RE: 9431/APP/2017/131

Please find enclosed revised drawing and my response to the drainage officer comments.

**Site plan with Drainage Layout - Rev I.pdf**
495K

PROJECT	1 PARKFIELD AVENUE, HILLINGDON, MIDDLESEX, UB10 0DF
DRAWING TITLE	SITE LAYOUT PLAN
DRG NO.	14254-P04
DATED	25-03-2015
APPROVED BY	PL

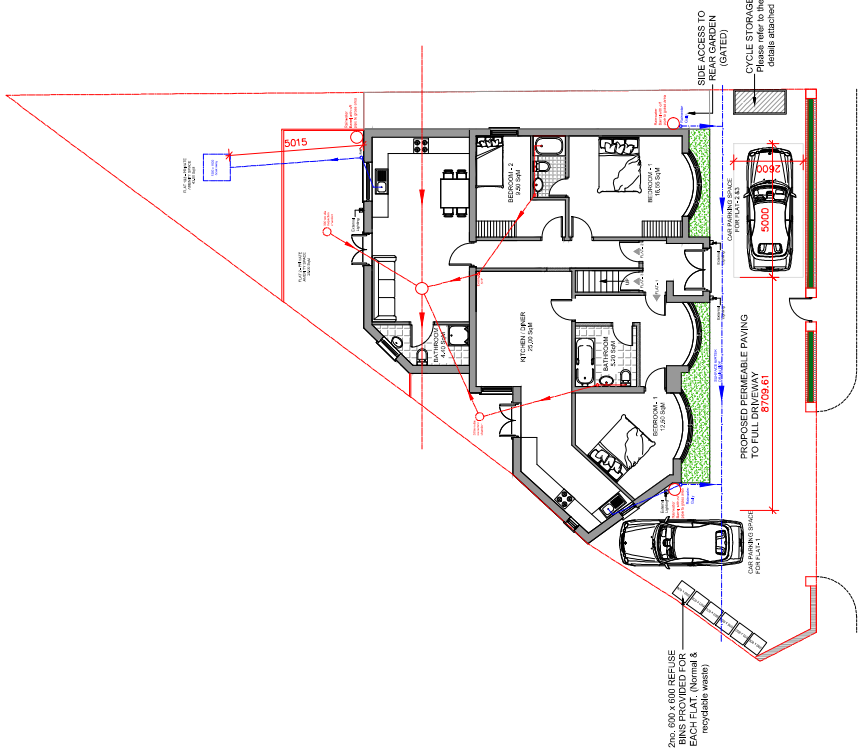
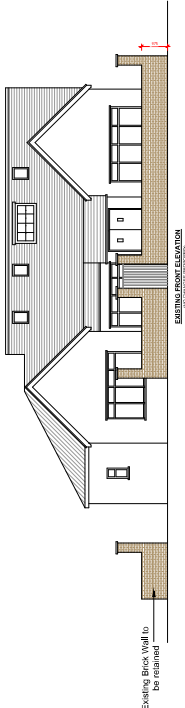
I have now received the attached updated comments in respect of this plan which will need to be addressed to discharge this condition

- Drawing revised to show front driveway to have permeable paving's
- Rainwater barrels are proposed at the front and the rear to reuse rainwater. Over flow pipe is connected to the barrel with outlet on the soft landscape area
- Rainwater will be collected in the barrels and the water would be utilised for watering plants, grass, washing bin area etc.
- Due to the scale of the site, it will be managed by the client. There is no mechanical system proposed for the site where maintenance agreement is required.
